Planning Services Sign Permit Review Form

Date of Submittal	Application Number	Applicant	Landowner
8/2/2022	SIGN2208-0001	Ginn Charles	Calvary Baptist Church

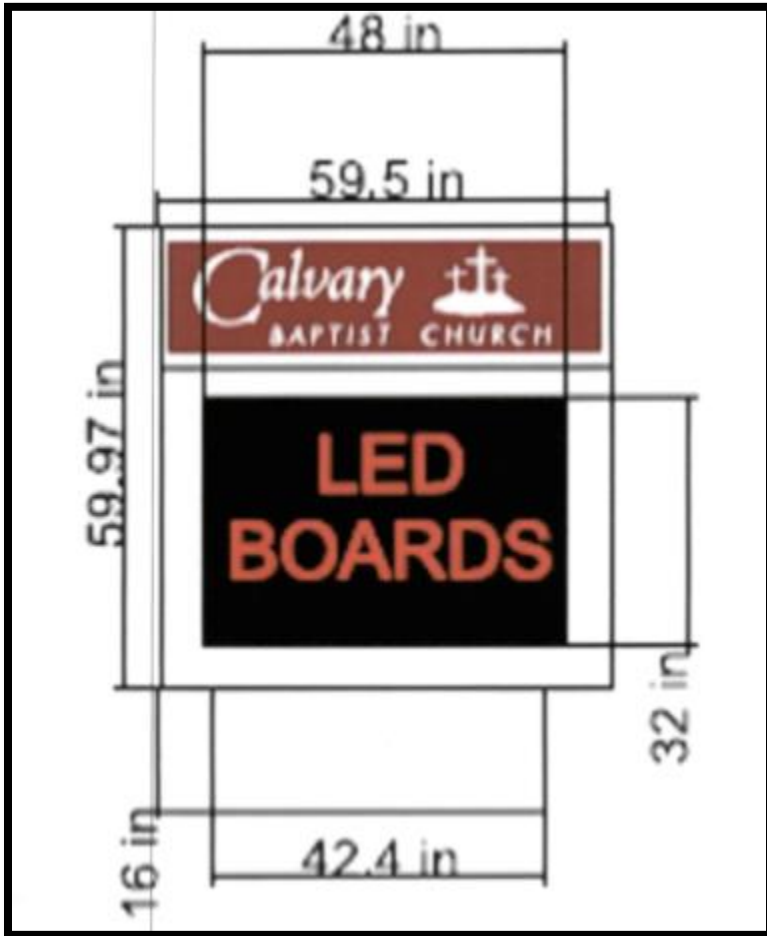
Comments	<p>-Please note that the current ground sign will be removed on the site plan. Only one sign is permitted per street frontage.</p> <p>-The proposed LED message board sign is too large. A maximum of 35 percent of the total area is permitted to be LED message board. Please reduce the size of the message board to a maximum of 10.3 square feet, or make the overall sign larger.</p> <p>-The measurement on the site plan requires revision. The measurement provided is from the centerline of the ROW. The measurement is required to be taken from the edge of right-of-way. I have included a plat recorded in 2002 in case it is helpful in determining the edge of ROW.</p> <p><u>Information Comment Only</u></p> <ul style="list-style-type: none"> - Electronic message board portion of sign cannot change messages more than 7 times per minute. No animated presentations or animated change of frame is allowed. This will be checked as a part of the zoning inspection.
